**RE: Request for Further Information
Lingard Private Hospital Expansion (SSD-60316710)**

This letter is submitted to the Department of Department of Planning, Housing and Infrastructure in response to the Request for Further Information (RFI) issued on 10 December 2024, relating to SSD-60316710 for the proposed expansion of the Lingard Private Hospital.

5 21 JUNE 11AM
Scale 1:500

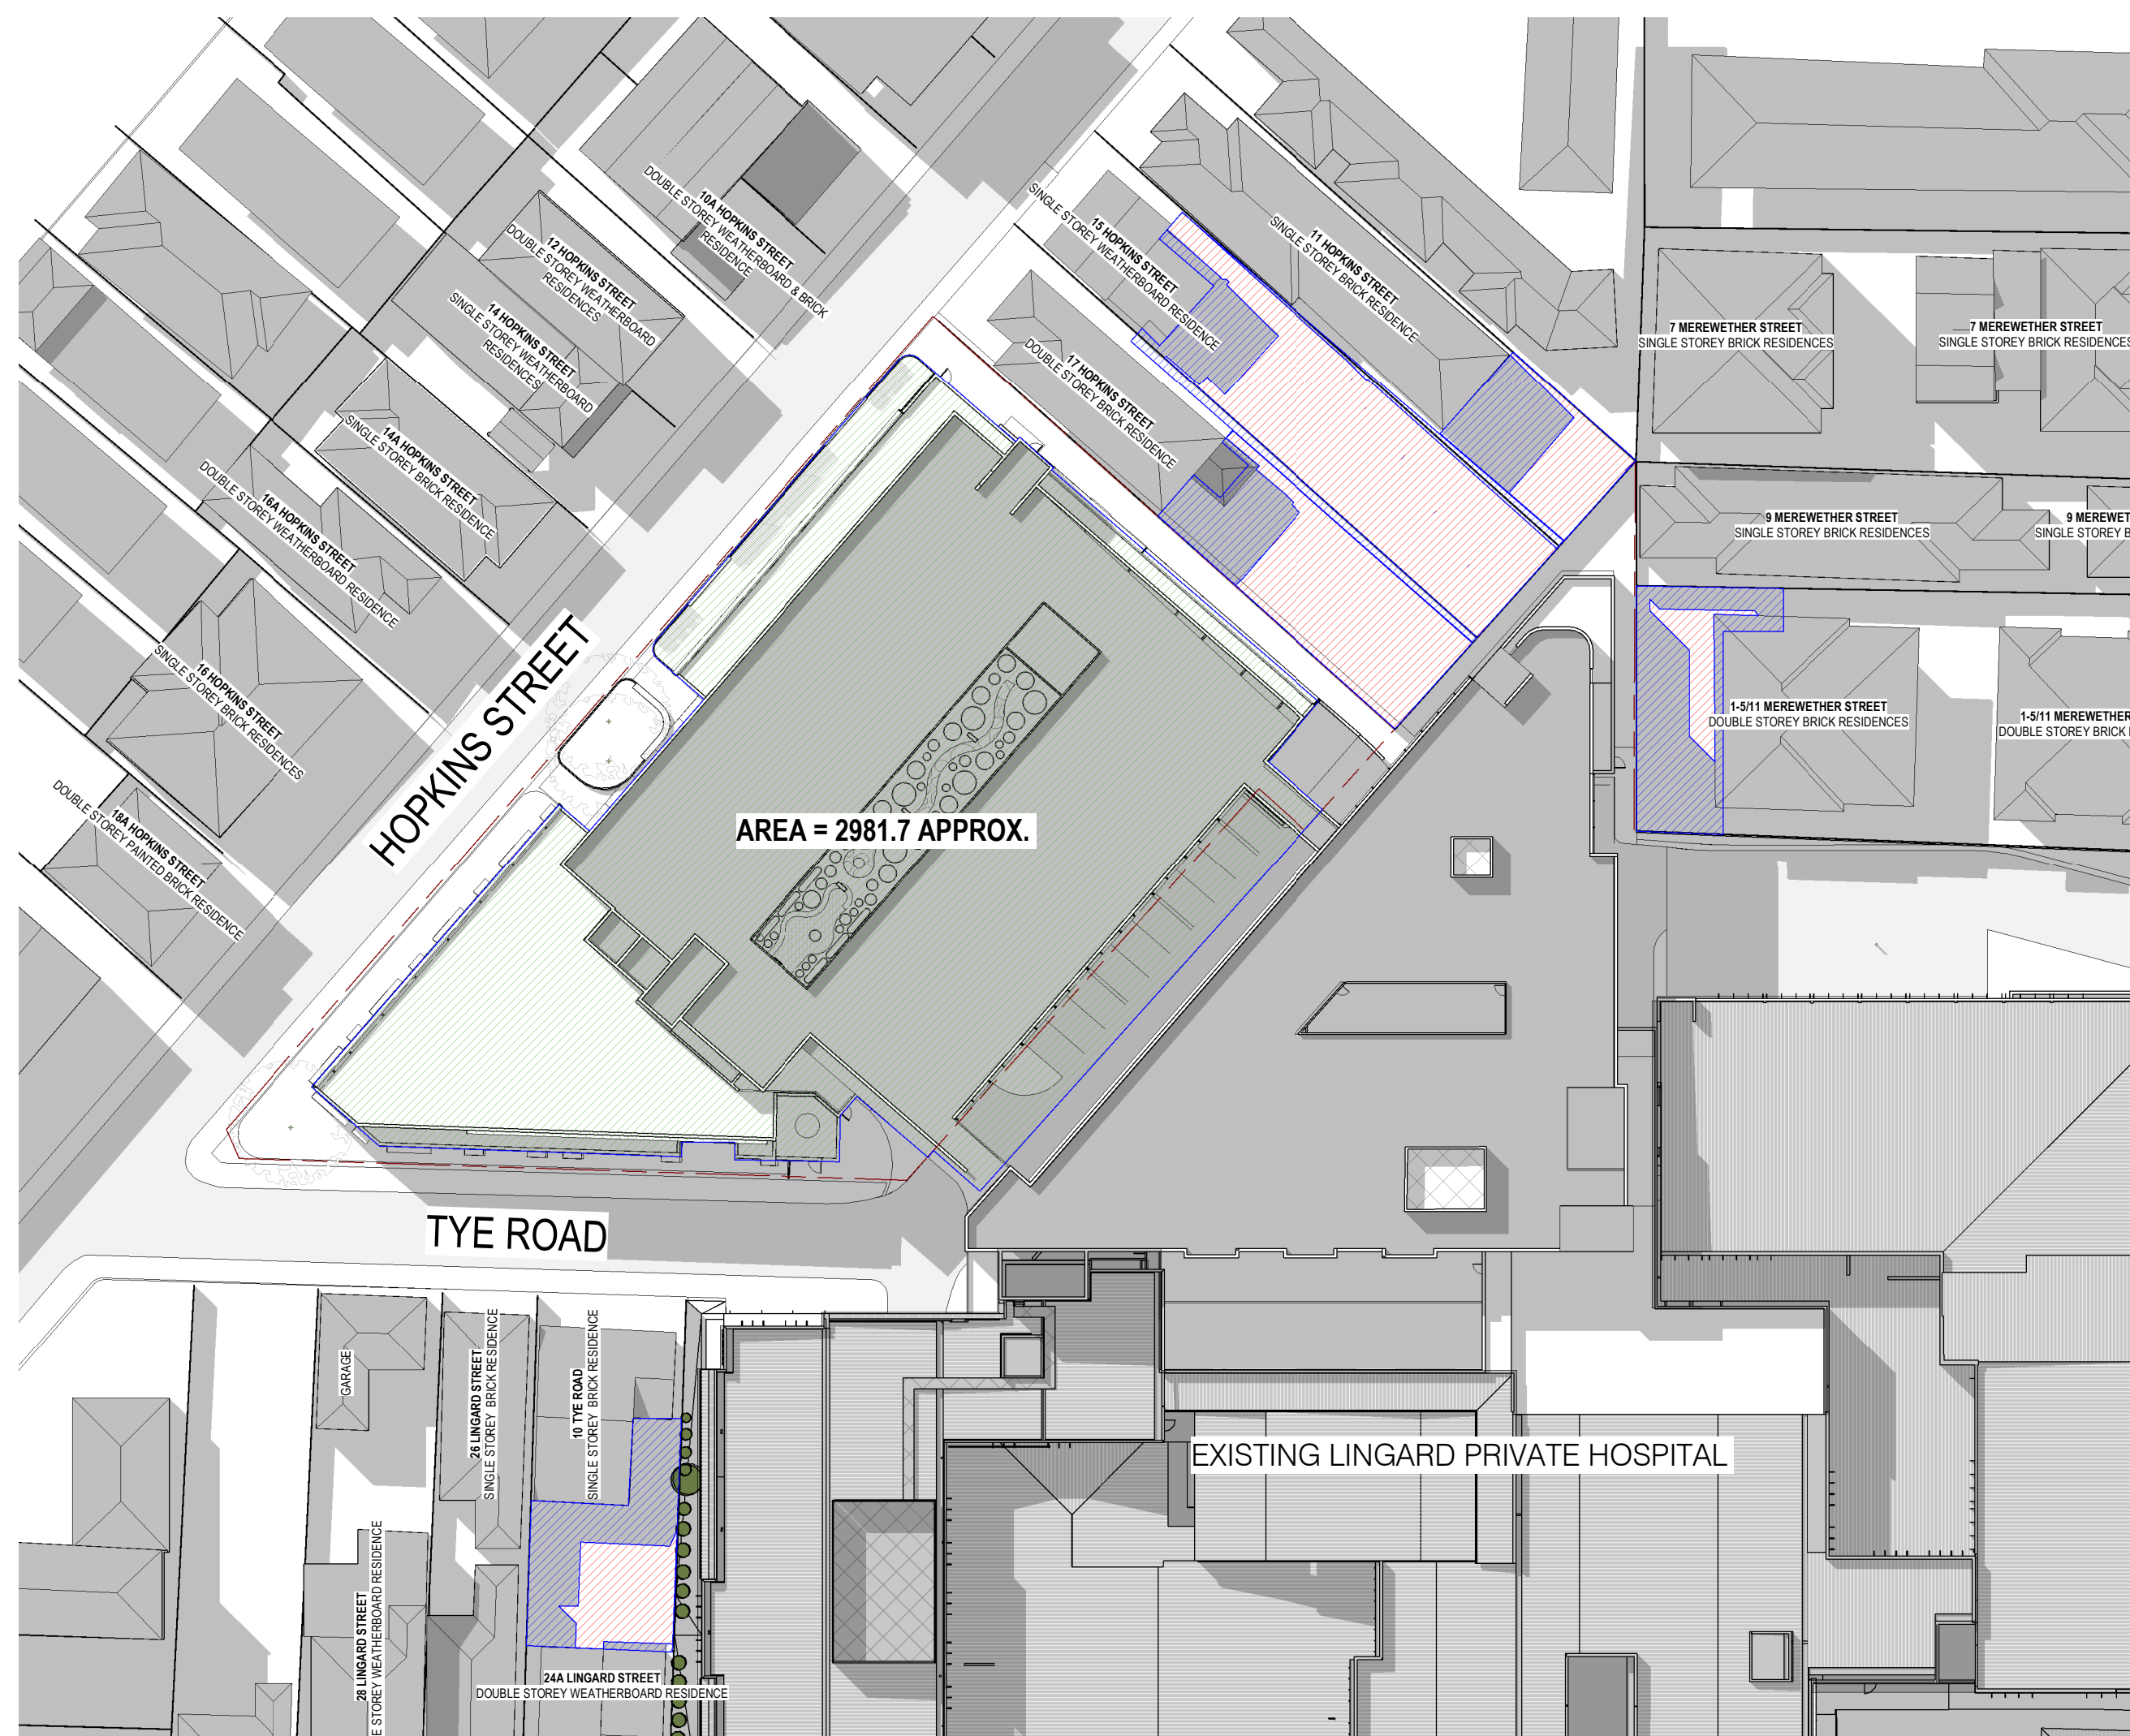
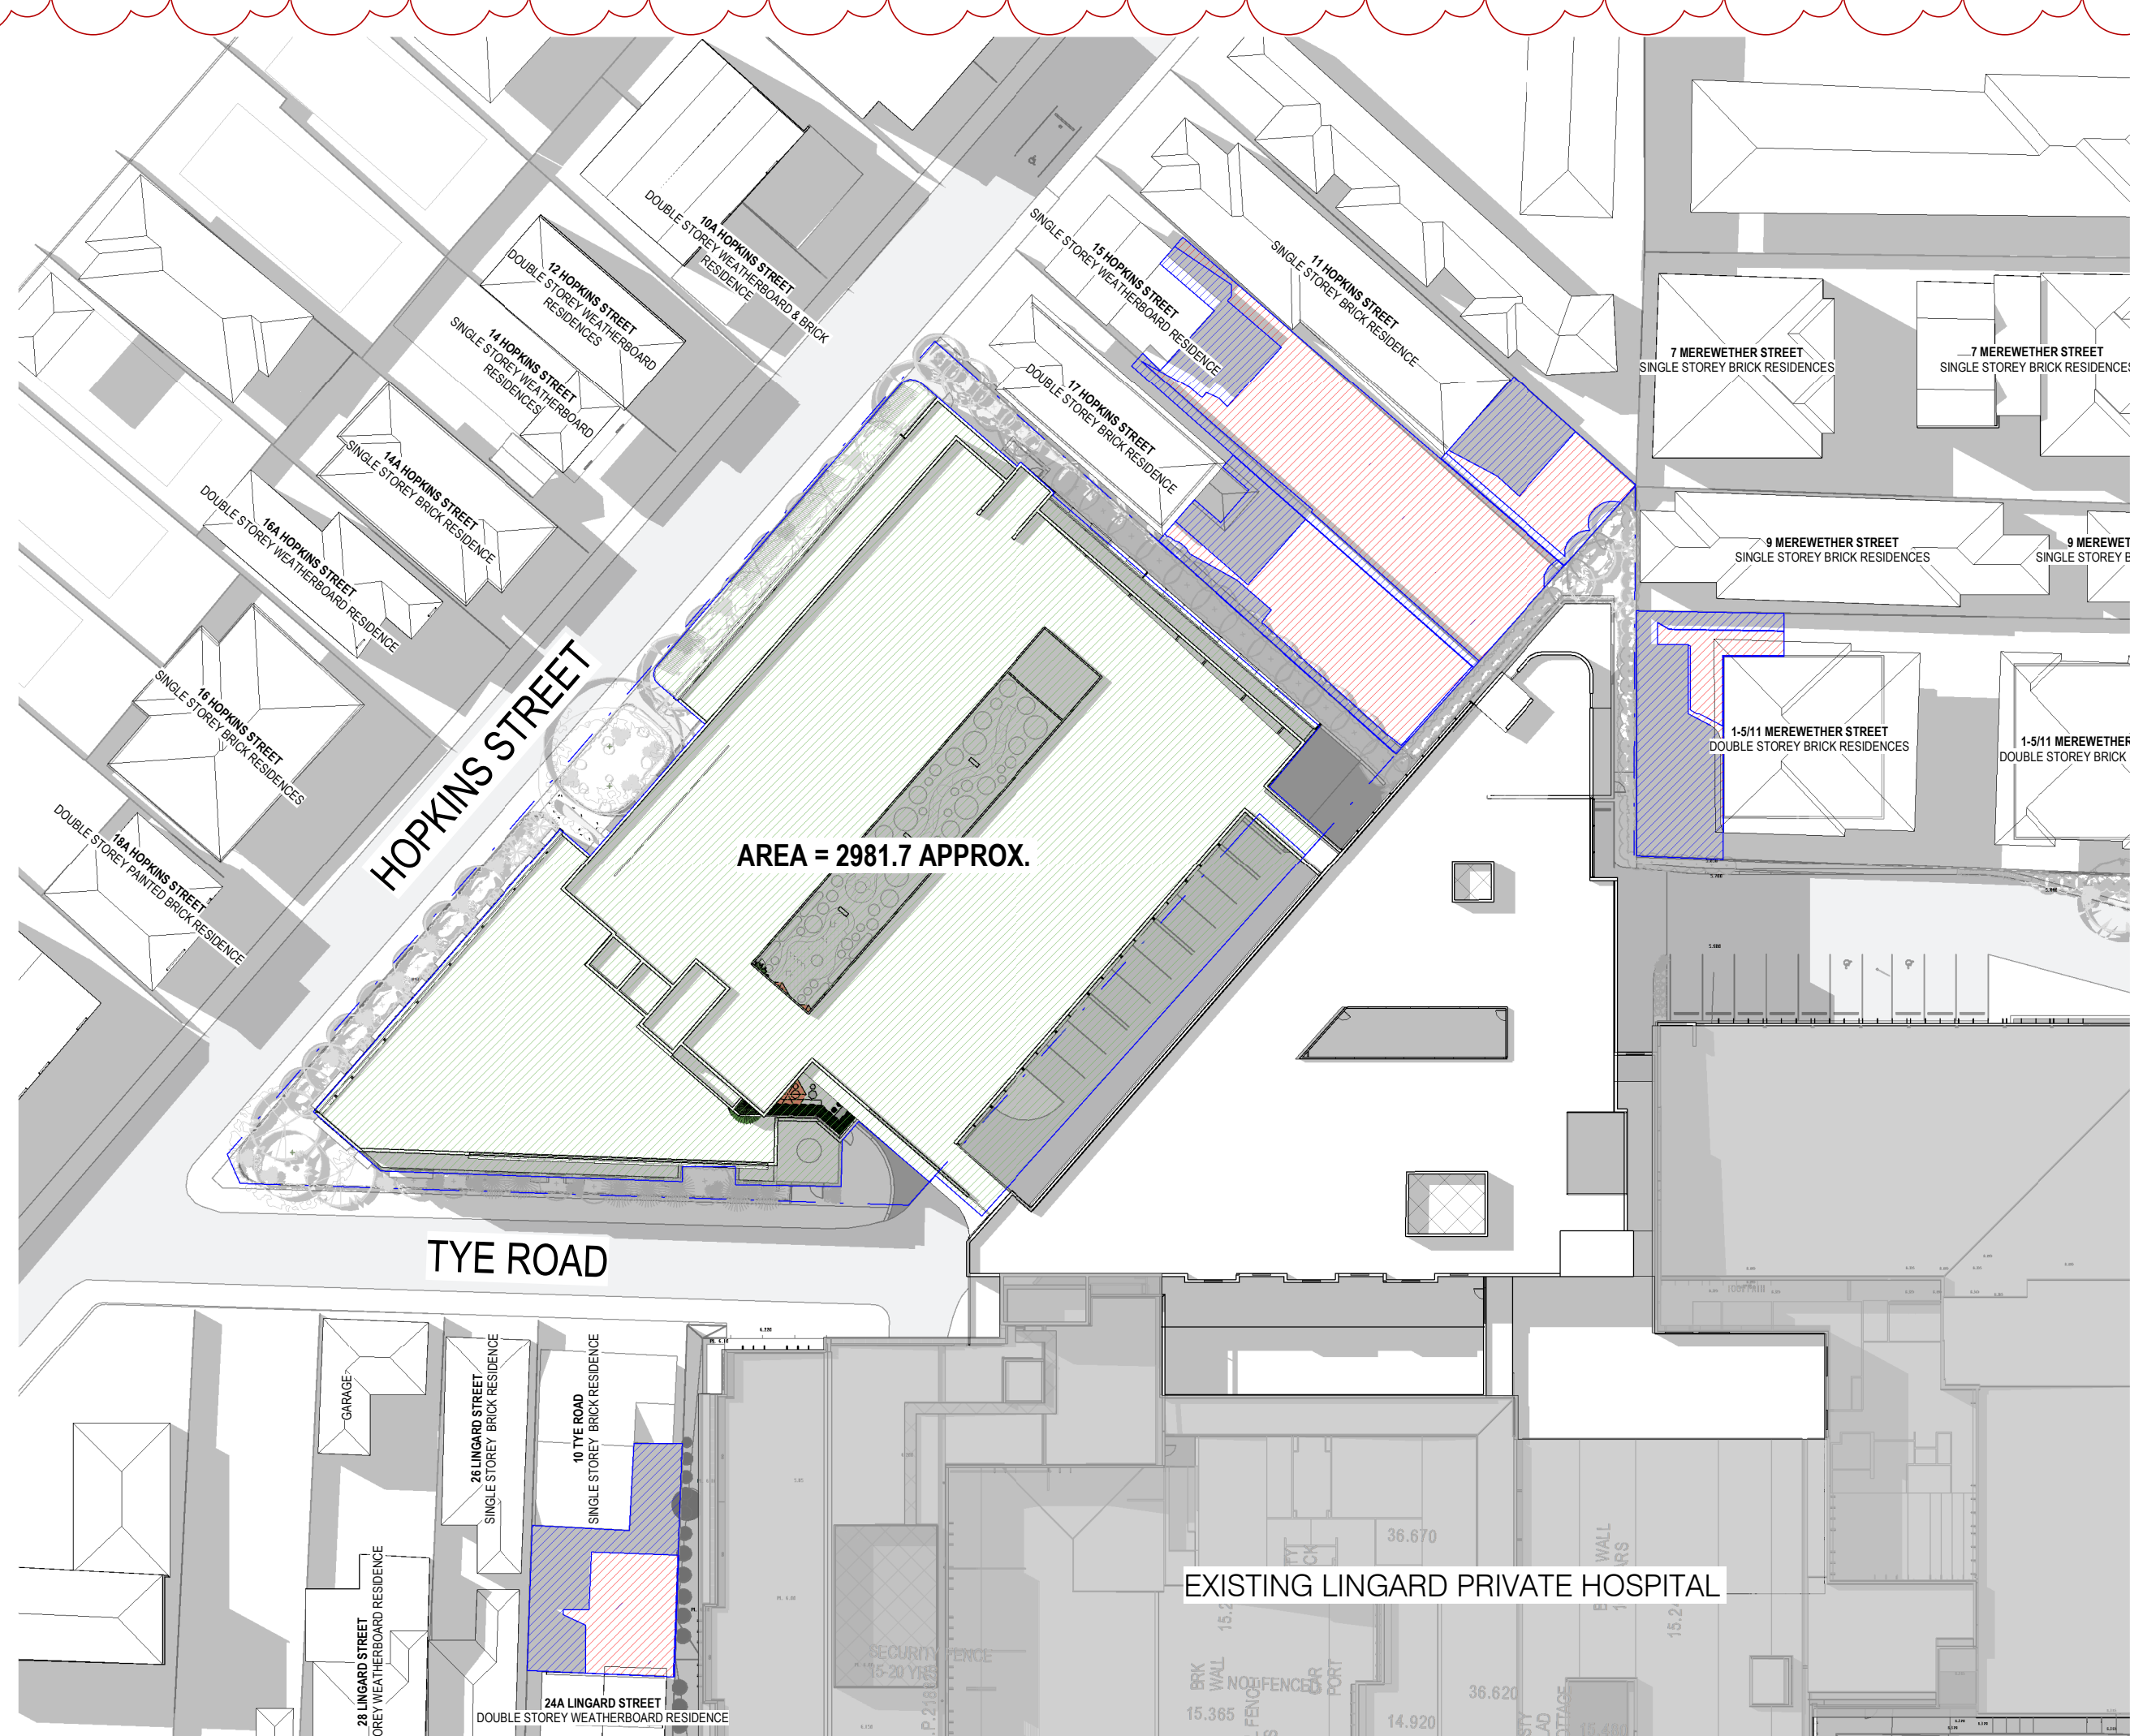
CN's concerns regarding residential amenity remain. The amended architectural plans do not include hourly shadow diagrams or 3D shadow analysis to identify the habitable rooms and private open space of residential properties, as previously requested. The shadow impact to Mitchell Park has not been adequately addressed.

The non-compliant height coupled with reduced setbacks on the eastern boundary of the Hopkins Precinct, exacerbate the amenity impacts. CN recommends the design is amended to reduce the bulk and ensure upper floor levels comply with the setback requirements and maximum building height development standard. CN recommends the applicant is required to submit additional shadow diagrams at hour intervals between 9am and 3pm during the June 21 winter solstice.

Additional shadow diagrams have been provided at Appendix A. The overshadowing of Mitchell Park is minimal, occurring only at 9 AM during winter. The affected area consists of large trees and on-street parking that would naturally be in shadow. The proposal ensures ample daylight reaches the trees and surrounding area at all other times.

The amended shadow diagrams include percentage calculations for the surrounding residential dwellings and confirm compliance. The most significant impact is on 11 Merewether Street in the afternoon; however, the existing shadow diagrams show that this is also the present state, refer to Figure 1 & 2 below. In the previous iteration of plans the second level wall was also setback further from this boundary.

The proposal does affect the adjoining Hopkins Street dwellings at 3 PM; however, there is no impact during the morning hours. The proposed setbacks are consistent with the existing dwelling setbacks in the area. While there is some overshadowing in the afternoon, the dwellings receive sufficient sunlight in the morning,

Overall, the proposed height variation does not result in any unreasonable adverse impacts on neighbouring properties in terms of bulk, scale, overshadowing, or privacy. The minor exceedance is justified by the functional necessity of the affected building elements and their limited contribution to the overall form, ensuring a well-balanced outcome that meets the intent of the planning controls while supporting high-quality urban design. Additional shadow diagrams are provided at Appendix A.
